Wise Engineering  
3915 Old Fairground Rd.  
Angier, NC 27501  
(919)894-2203

Subject: 61 Rock Ridge Pl, Coats, NC 27521

At your request, a representative from Wise Engineering (WE) reviewed the existing footing excavations located at 61 Rock Ridge Pl, Coats, NC 27521. Specifically, we reviewed footing excavations for the entire home to provide a third-party inspection prior to concrete placement.

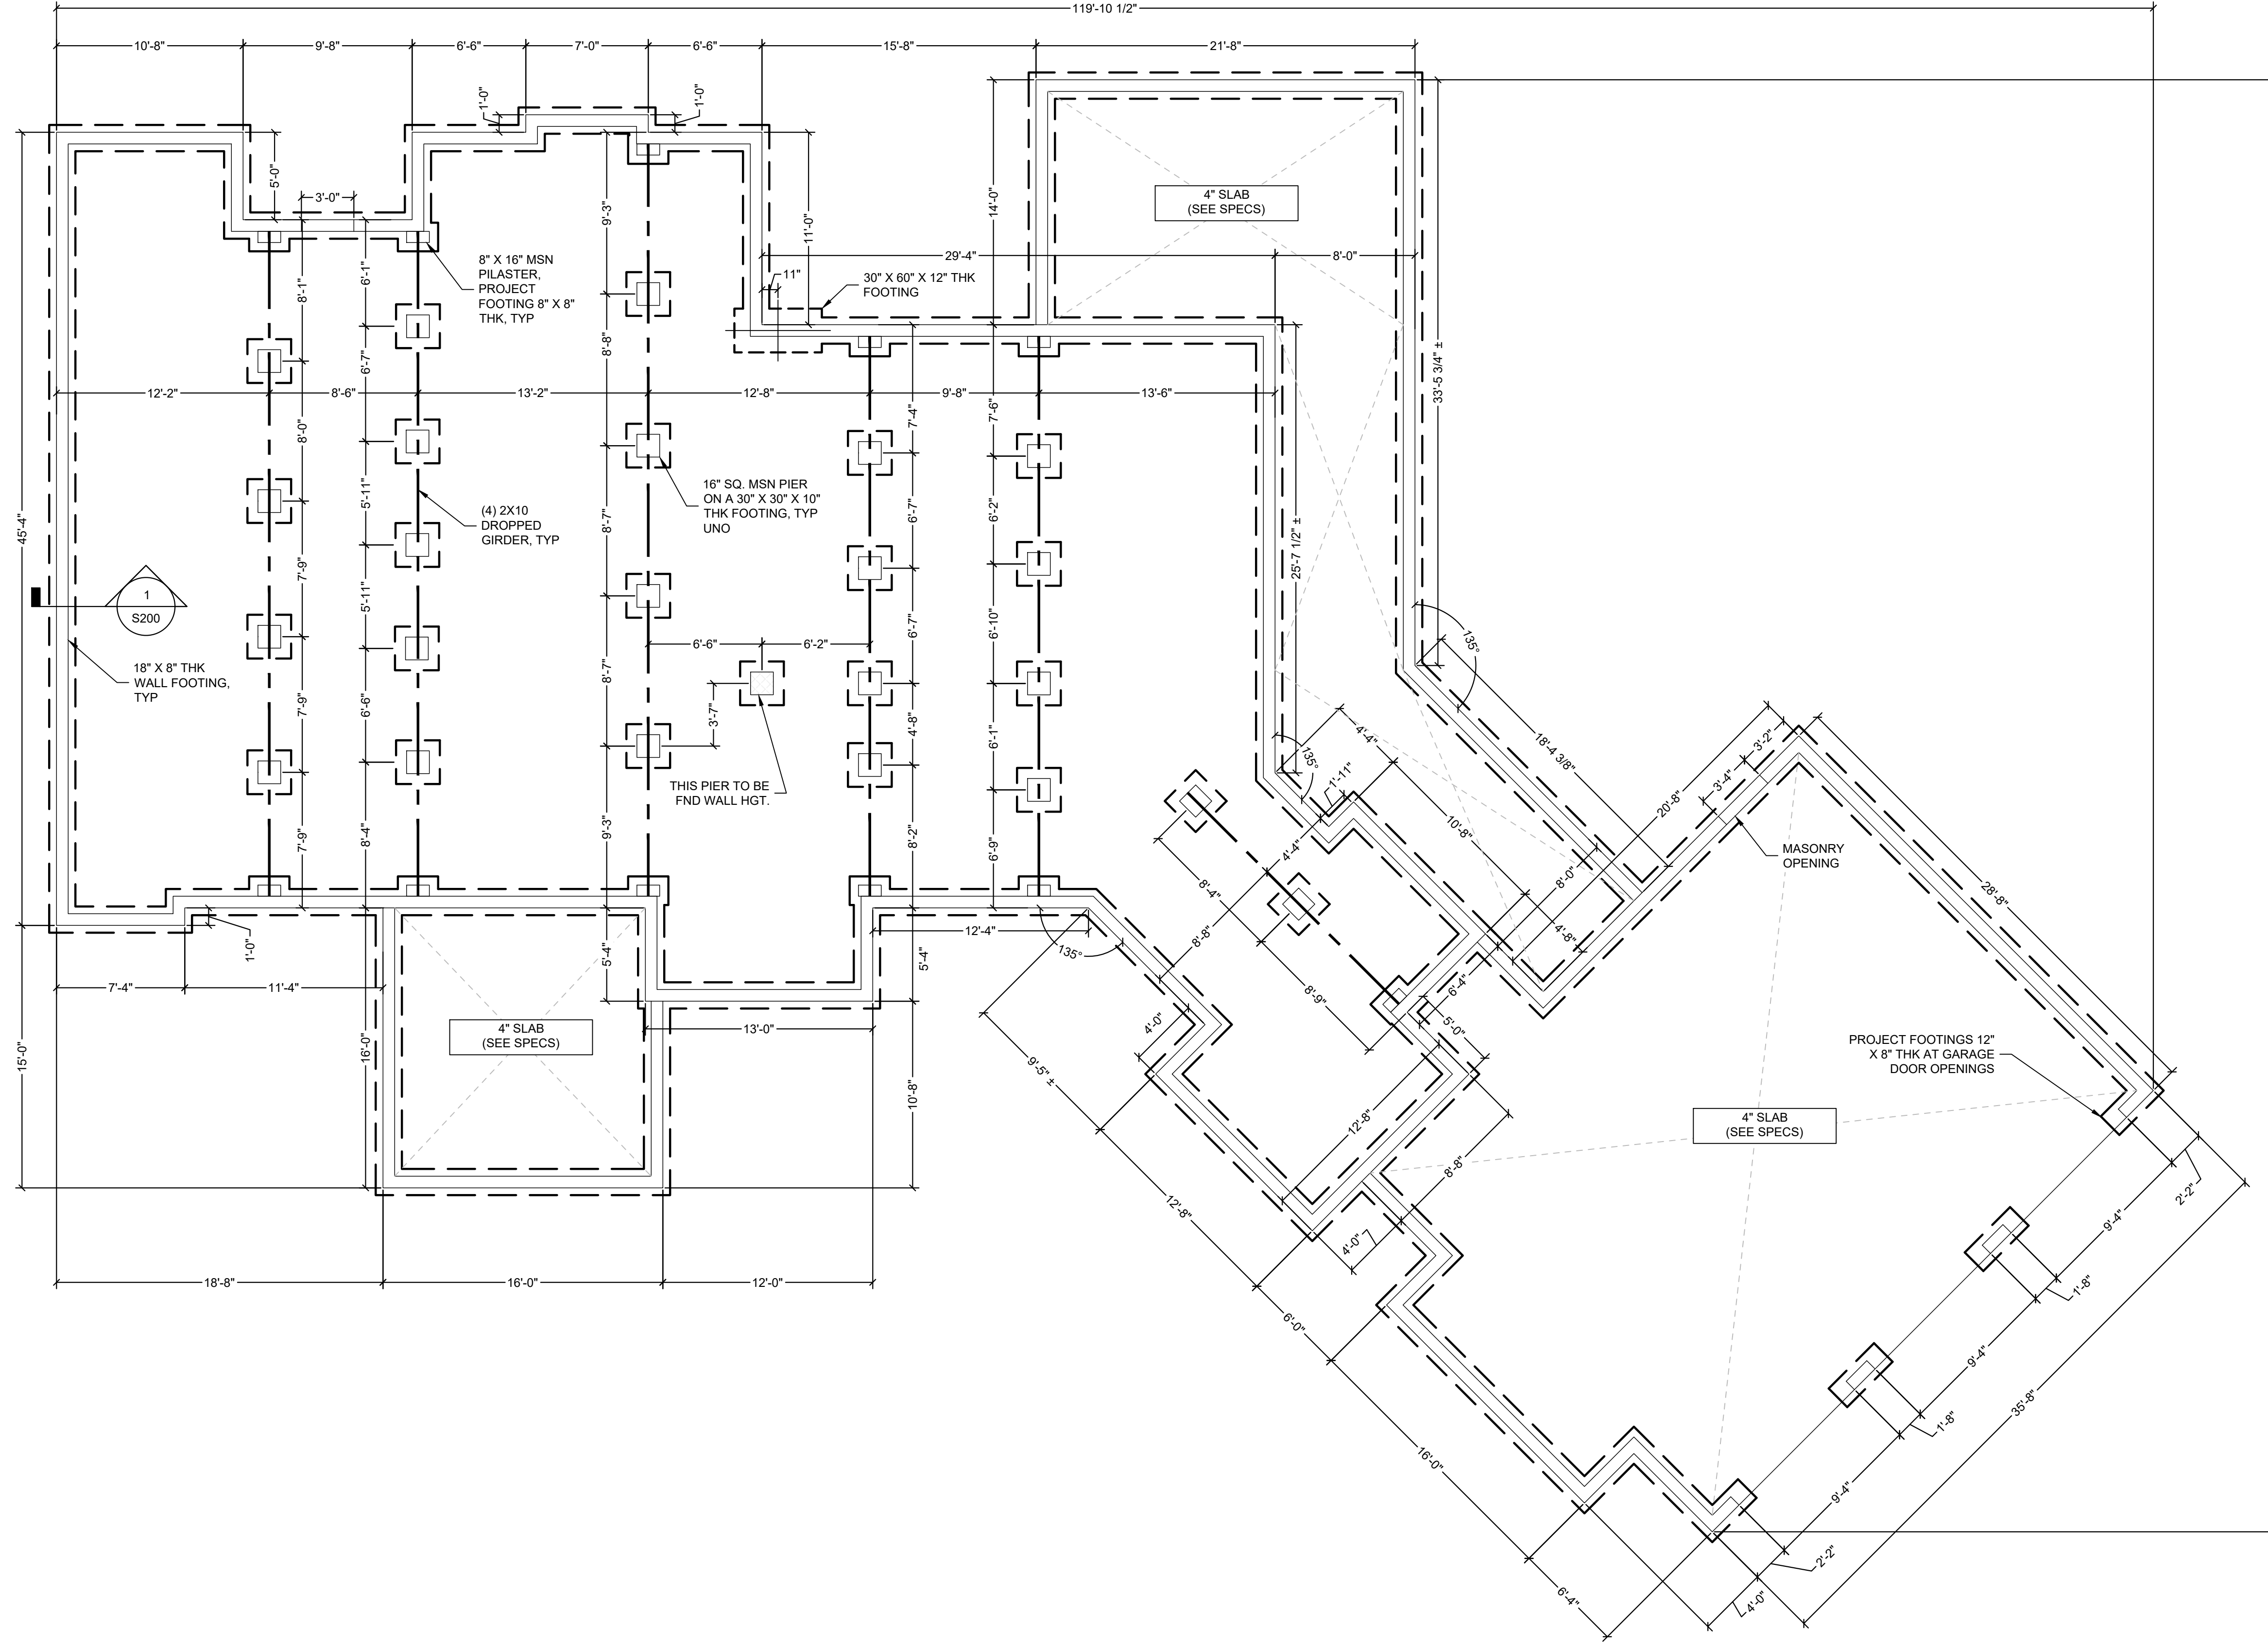
Based on our observations and analysis, the dimensions of the footing excavations were constructed in general compliance of the provided construction documents and the 2018 North Carolina Residential Building Code. Additionally, the soil within the footing excavations is structurally adequate to support the anticipated loading conditions (2000PSF bearing capacity).
